Subject: Re: Sefter Road, Bognor Regis - discharge of condition for drainage

My comments are as follows:

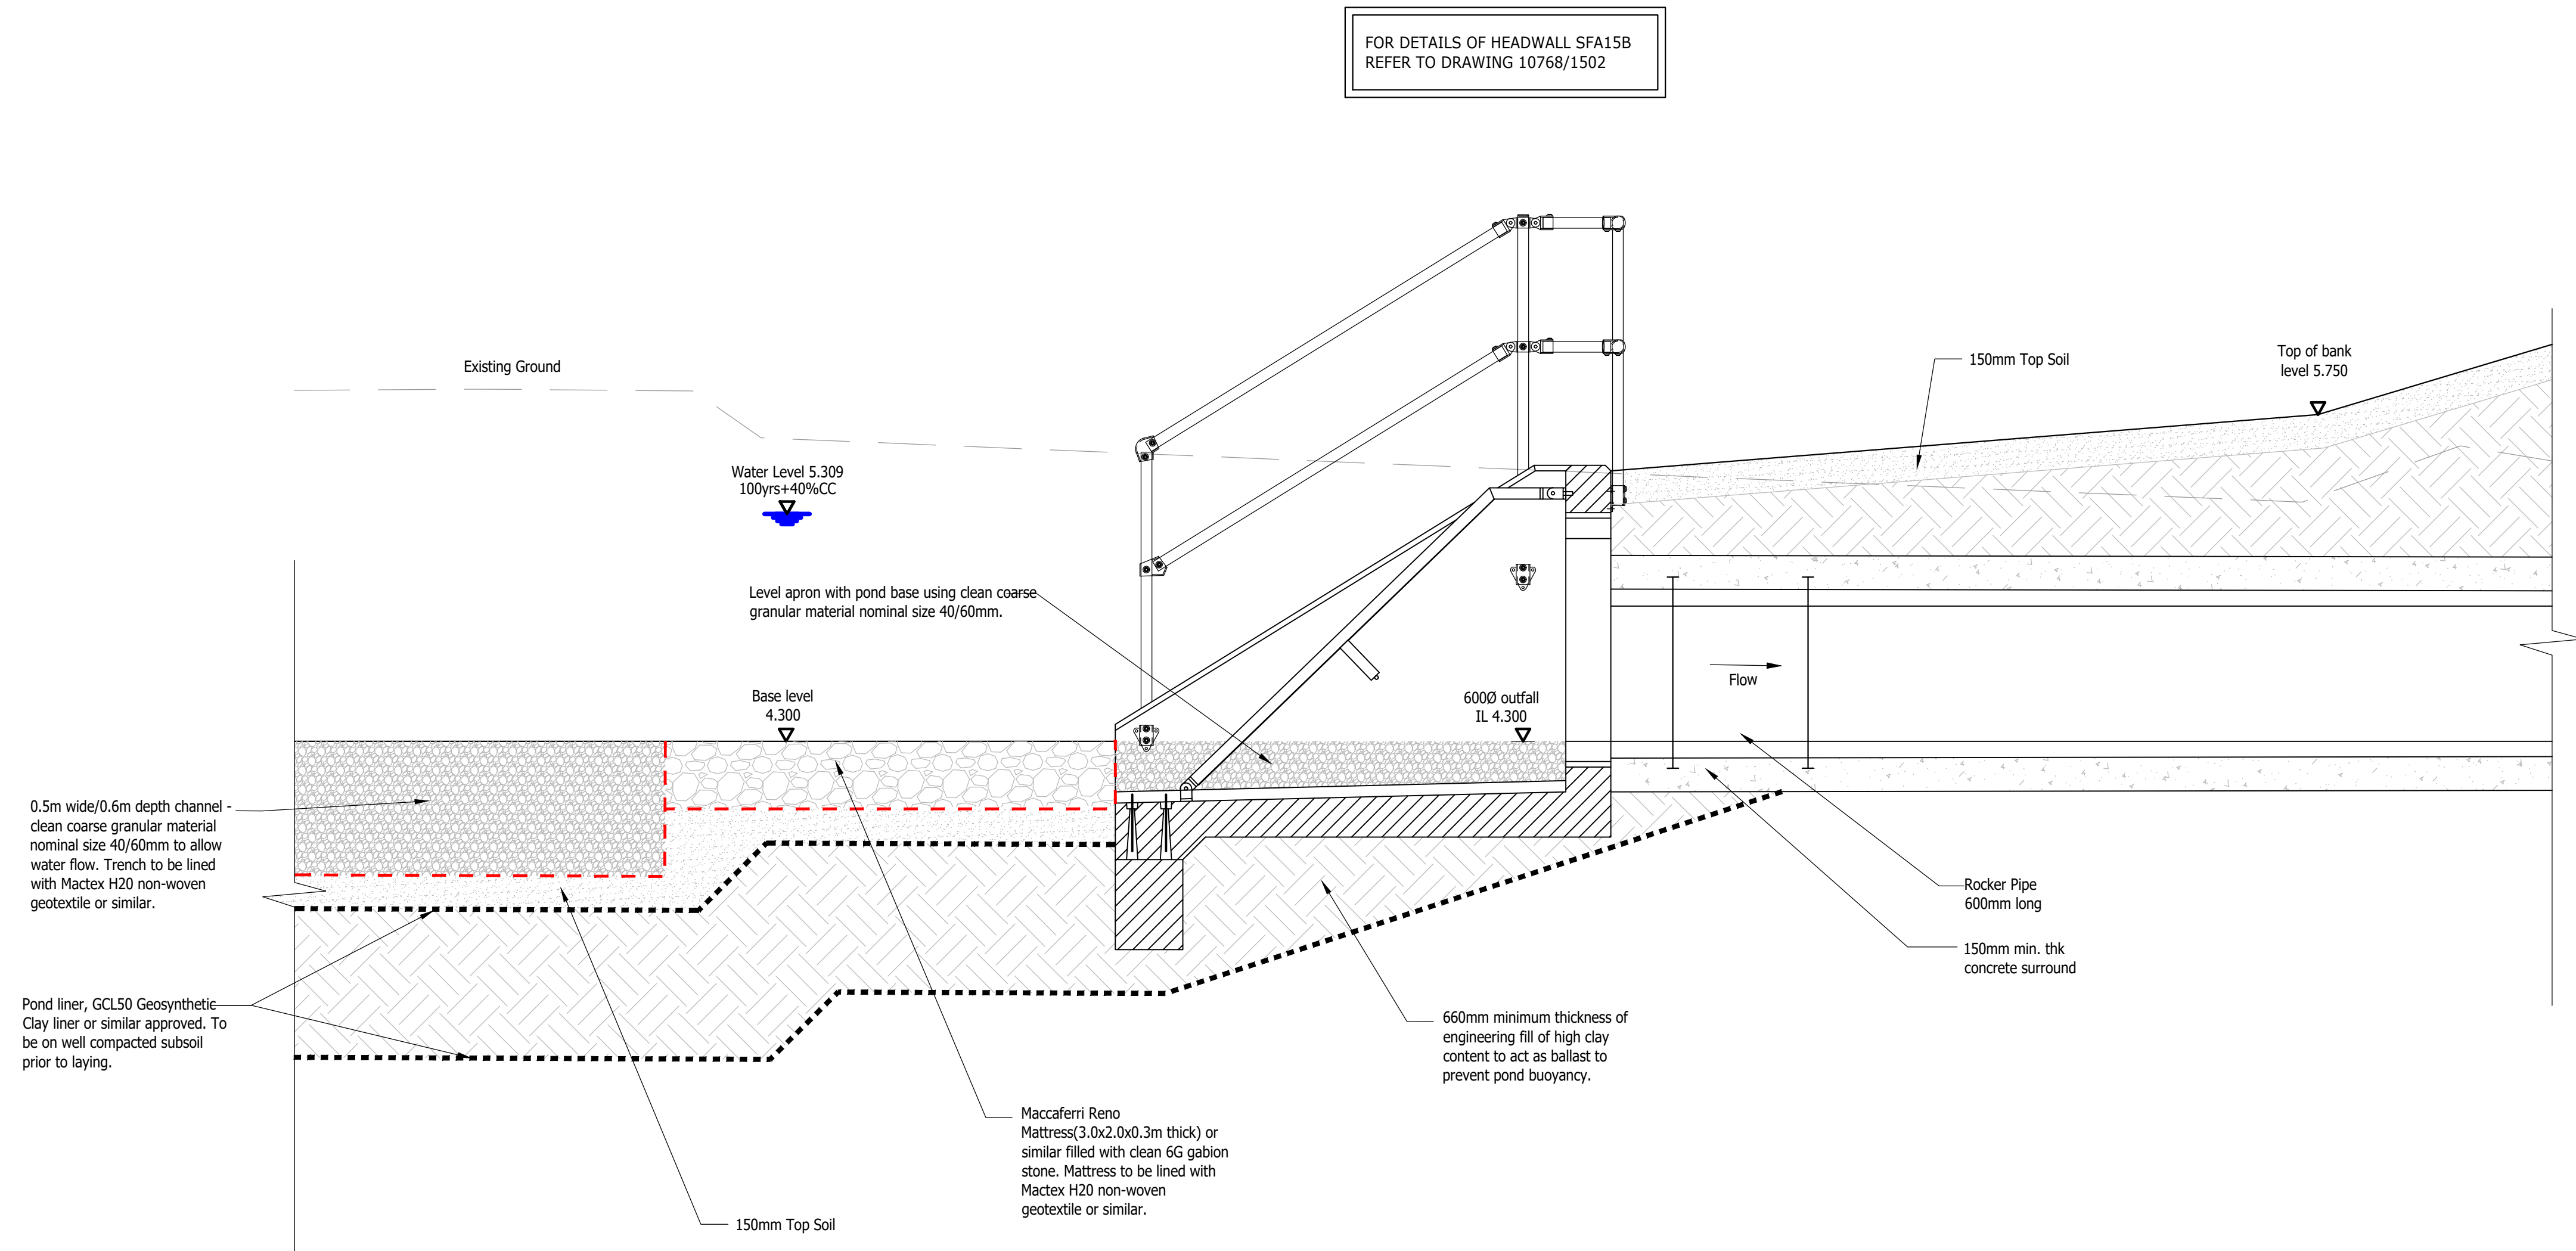
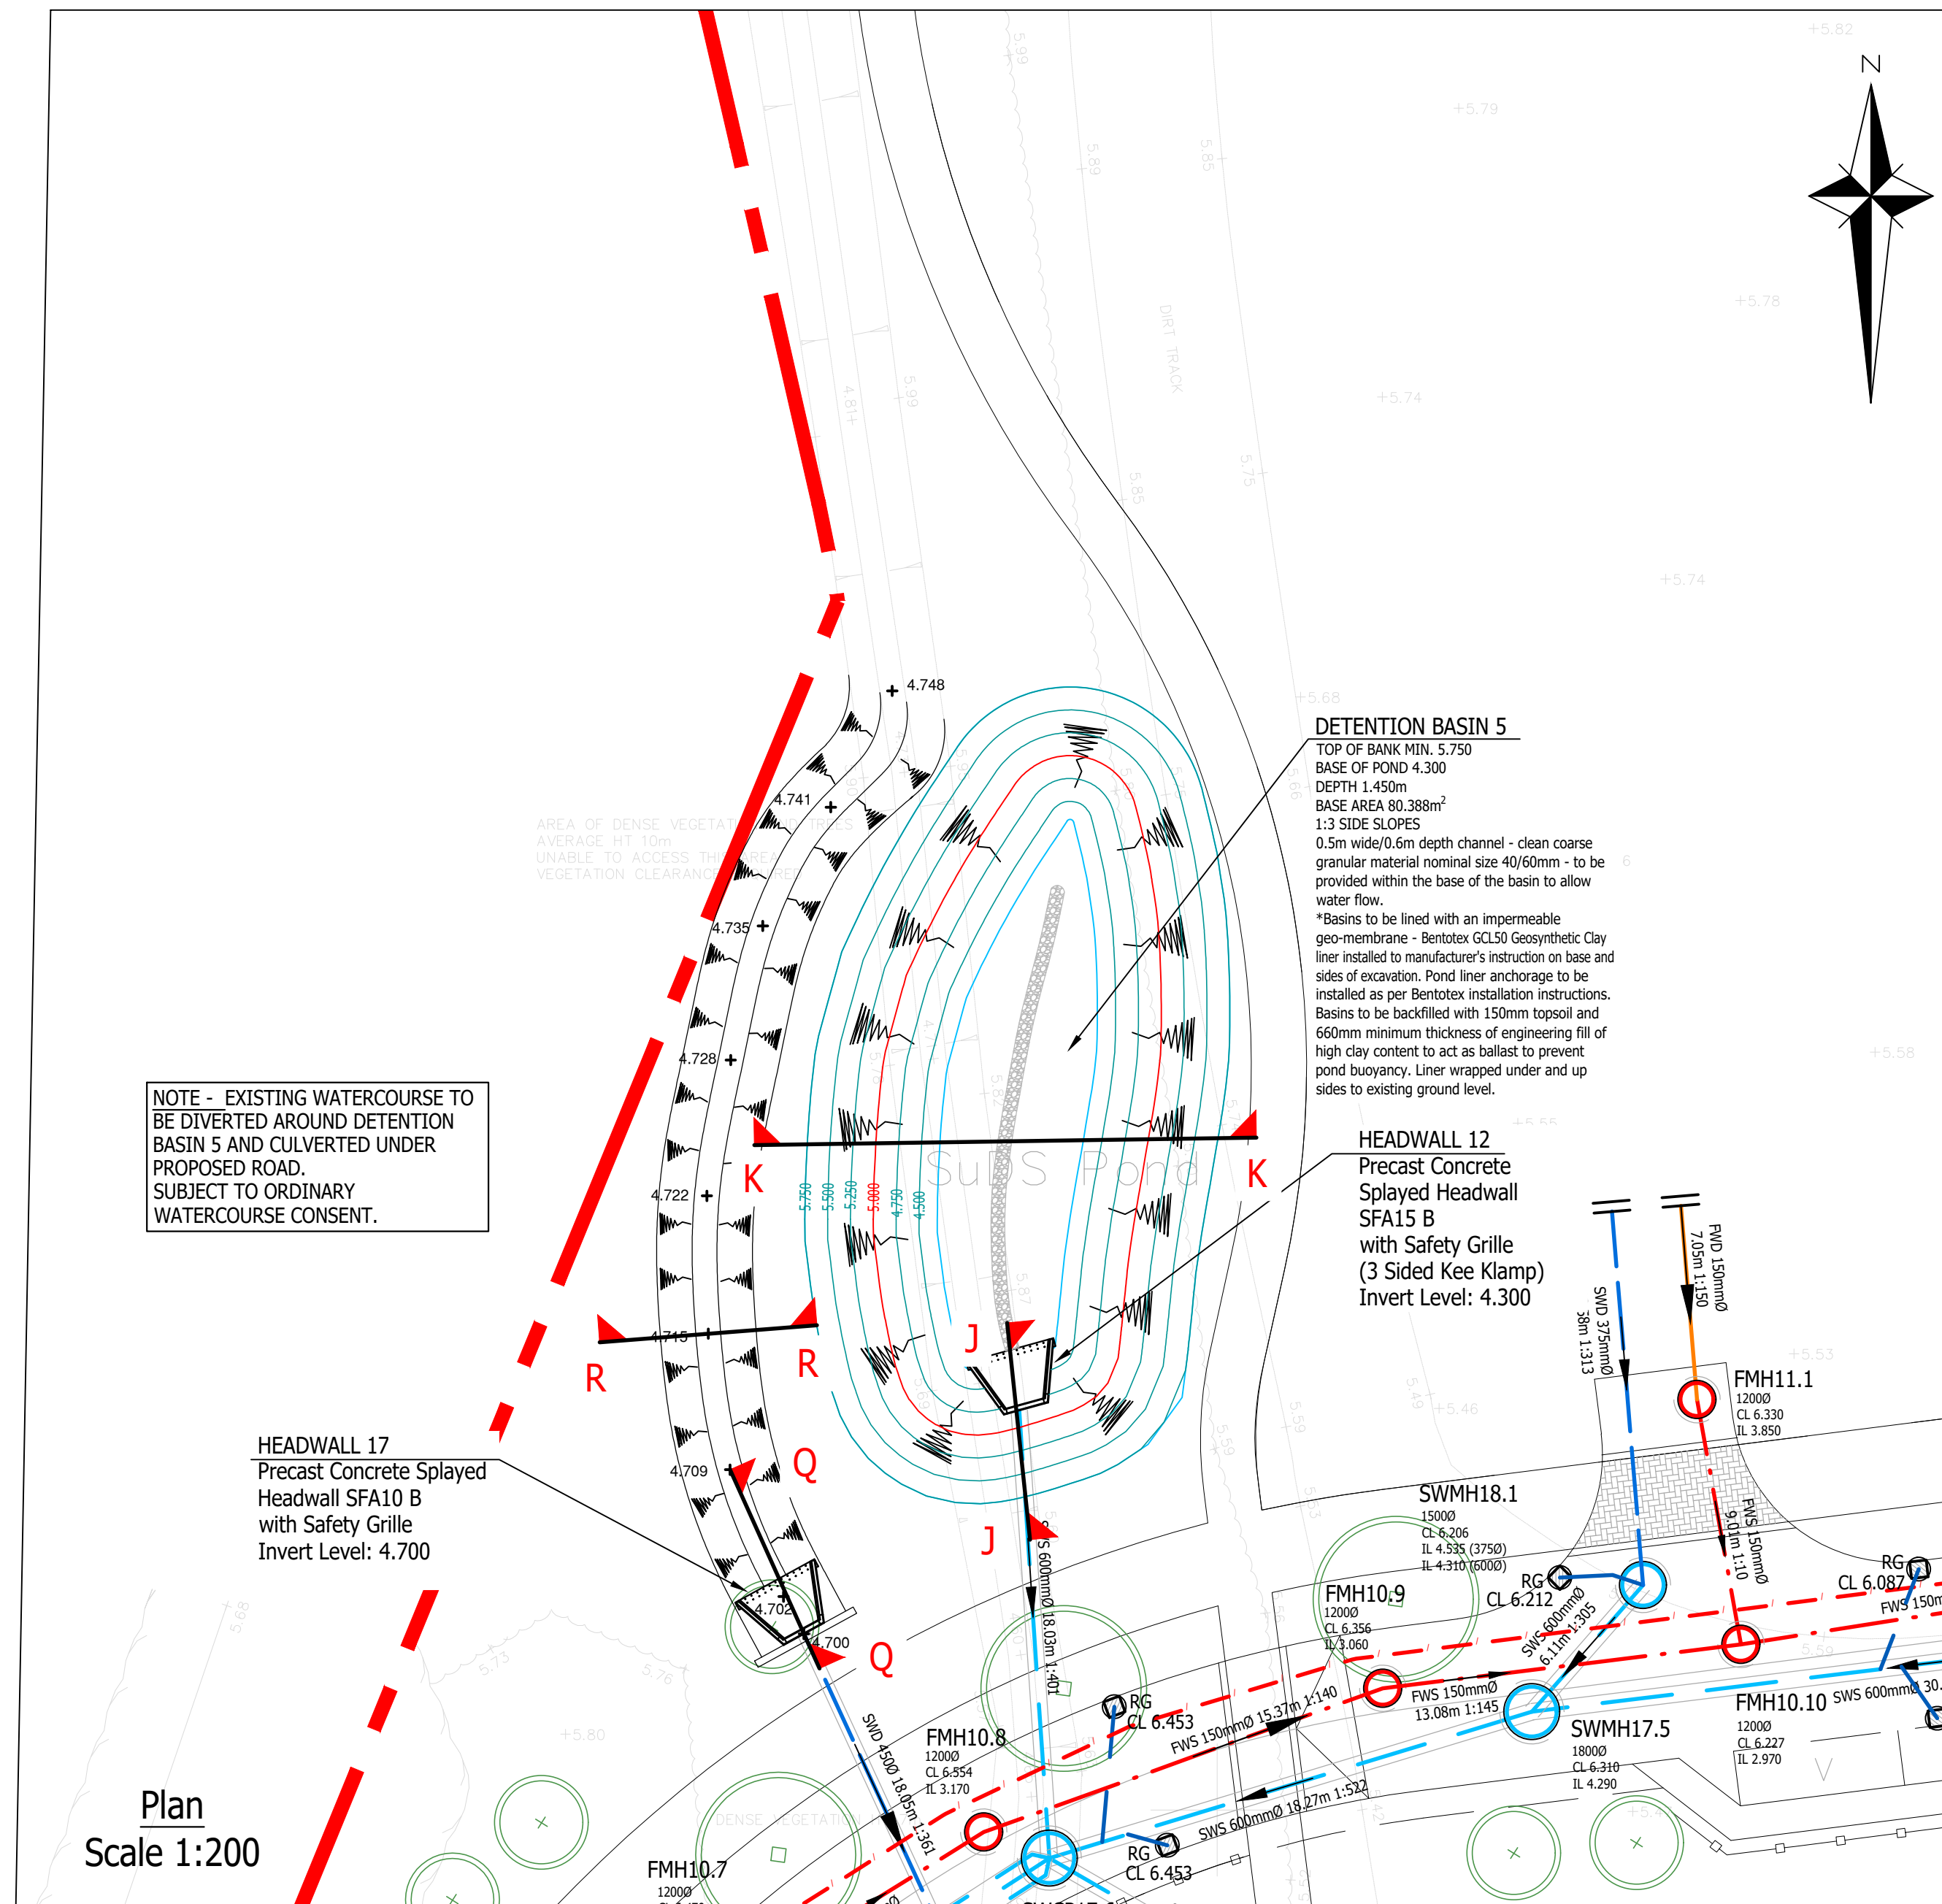
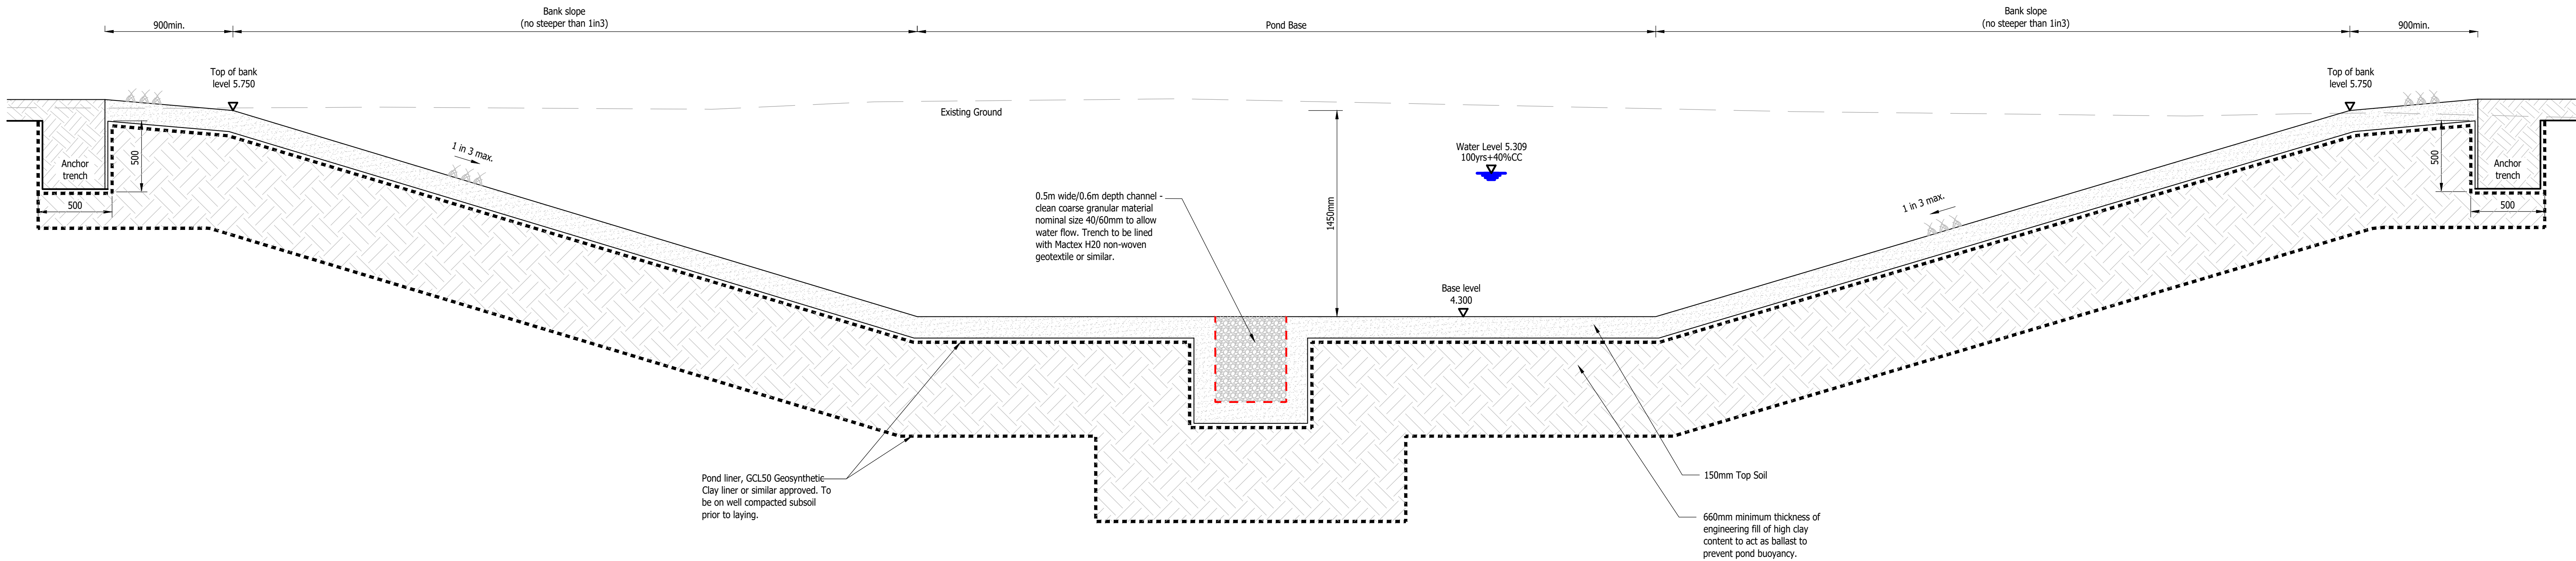
10. Catchment area plans should be provided.
11. Construction details- please provide at least two perpendicular specific sections per basin.
12. Please provide construction detail drawings of the proposed watercourse diversion.

ROAD GULLY DETAIL (1:20 Typical)

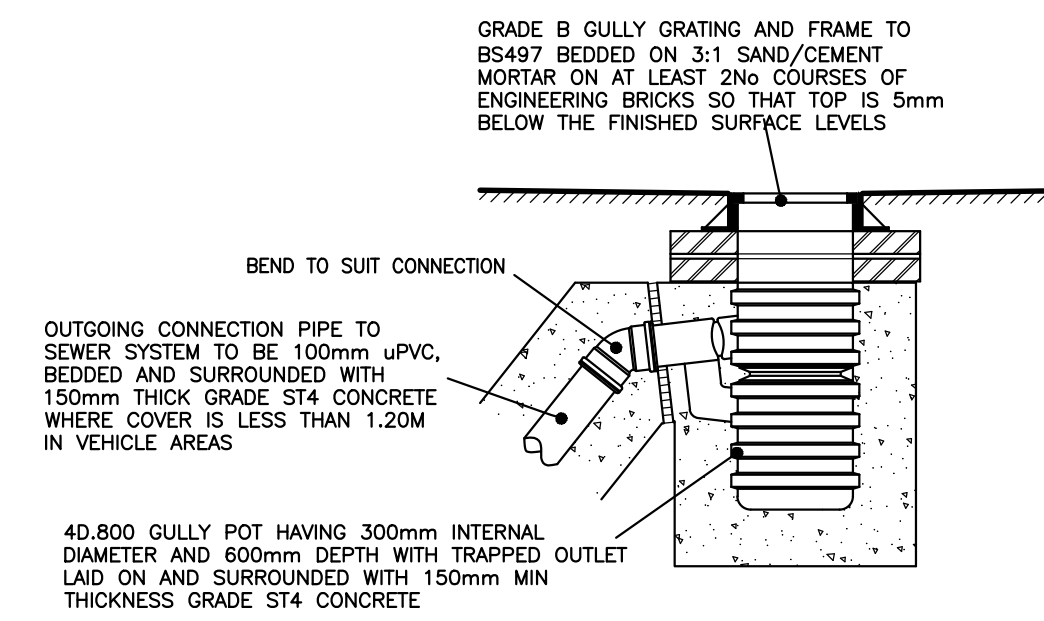
13. Headwall details should include 45 degree cranked grilles.
14. Road gulleys should be labelled with cover level.
15. Please apply a factor of safety of 1.1 to destabilising forces, and a factor of 0.9 to stabilising forces in flotation calculations.
